**WEST SUSSEX COUNTY COUNCIL
STRATEGIC PLANNING CONSULTATION**

SUBJECT: WA/6/14-Change of use of store to single dwelling with porch extension and alterations.
This application is a departure from the development plan

Walberton House, The Street, Walberton, West Sussex, BN18 0PJ

WALBERTON HOUSE
THE STREET
WALBERTON BN18 0PJ
CONVERSION OF STORE
TO COTTAGE
BLOCK/SITE PLAN
FOR NICKI SHALE-HESTER

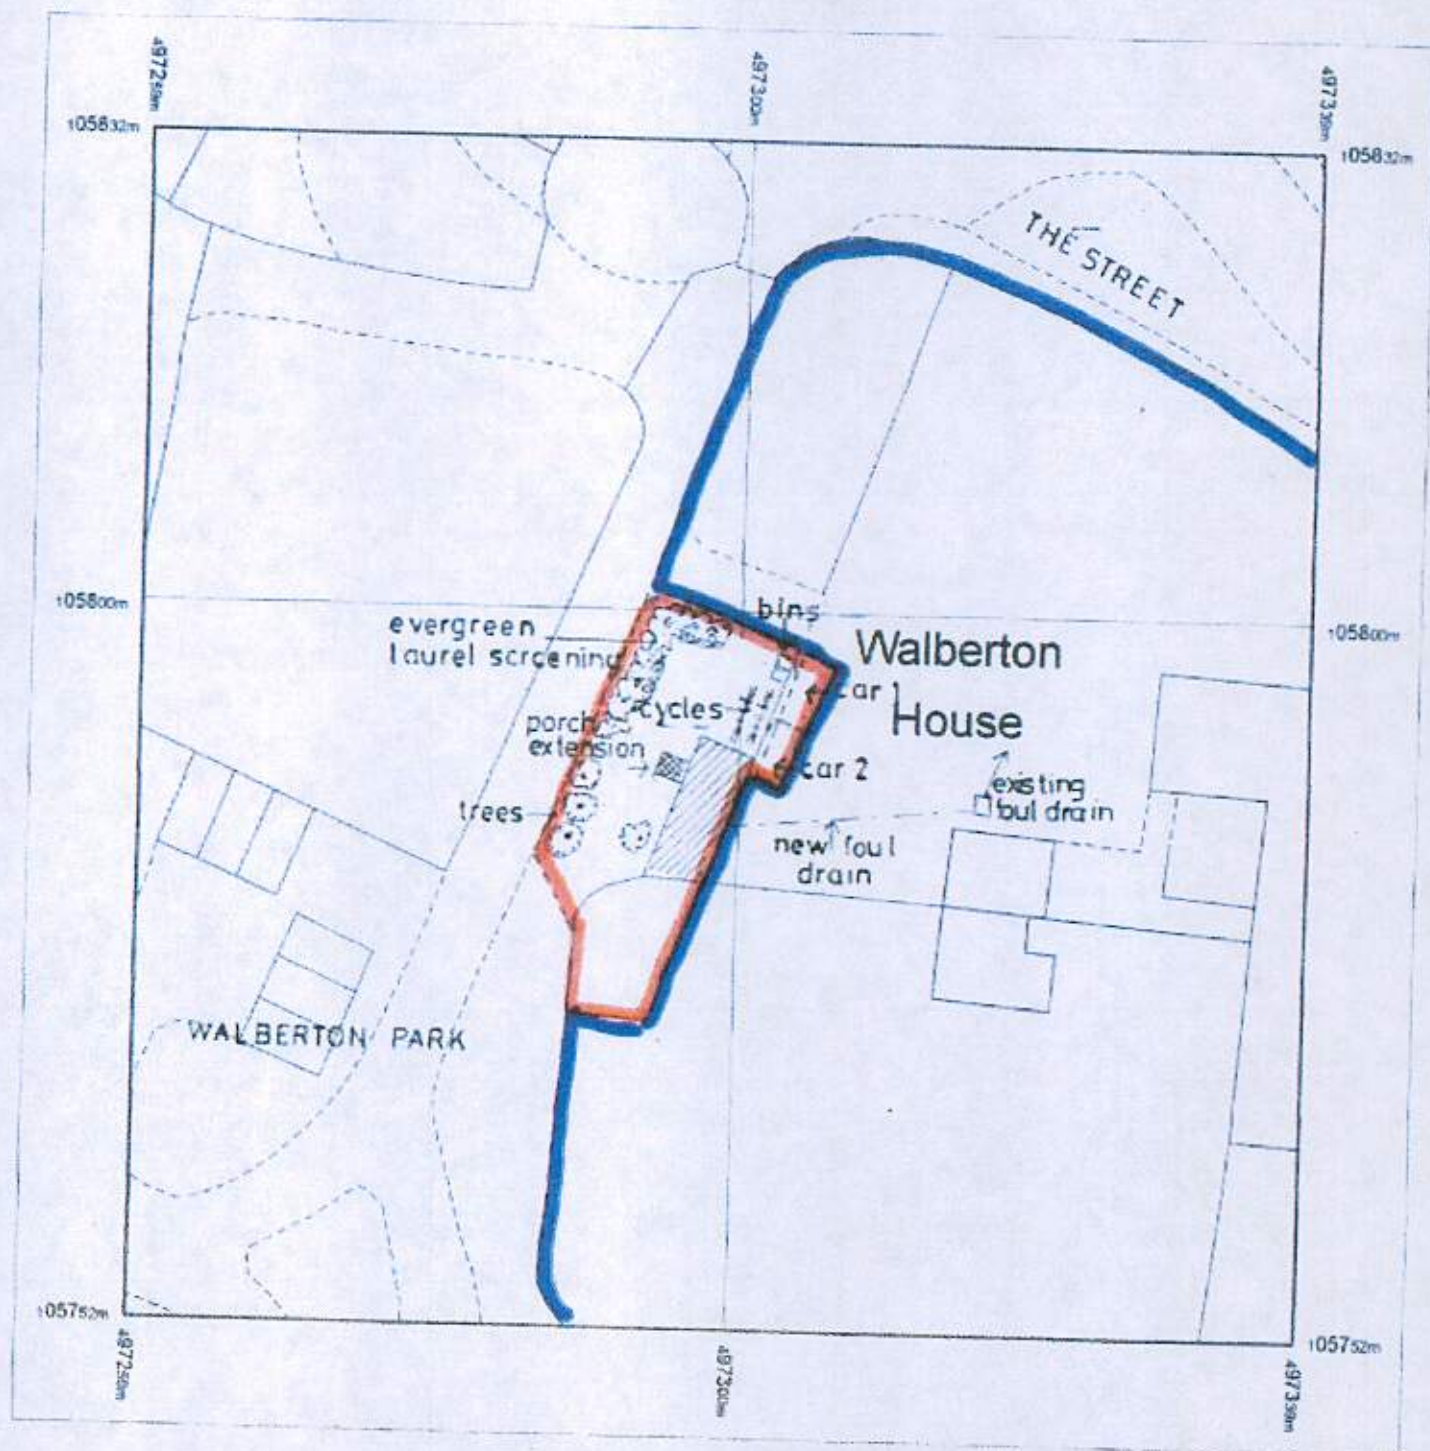
It is assumed that the existing access which currently serves the store will be utilised for this proposal. Whilst there are minor alterations that are proposed to the car parking and on-site turning, there are no recorded incidents in the vicinity of this access. In terms of vehicular movements, the proposal is unlikely to result in any material increase or any detrimental impact.

2 parking spaces will be provided, this number is considered appropriate, and no highway safety concerns would arise through this provision. Cycle parking should be included however; this must be secure, covered and be capable of storing at least one cycle per bedroom of the proposed dwelling. The actual details of the cycle parking facilities should be submitted to and approved by the Local Planning Authority (LPA). To accommodate cycle parking it would be recommended that any cycle store should have minimum dimensions of 2m x 1m.

If the LPA are minded to approve this application a condition securing cycle parking should be included.
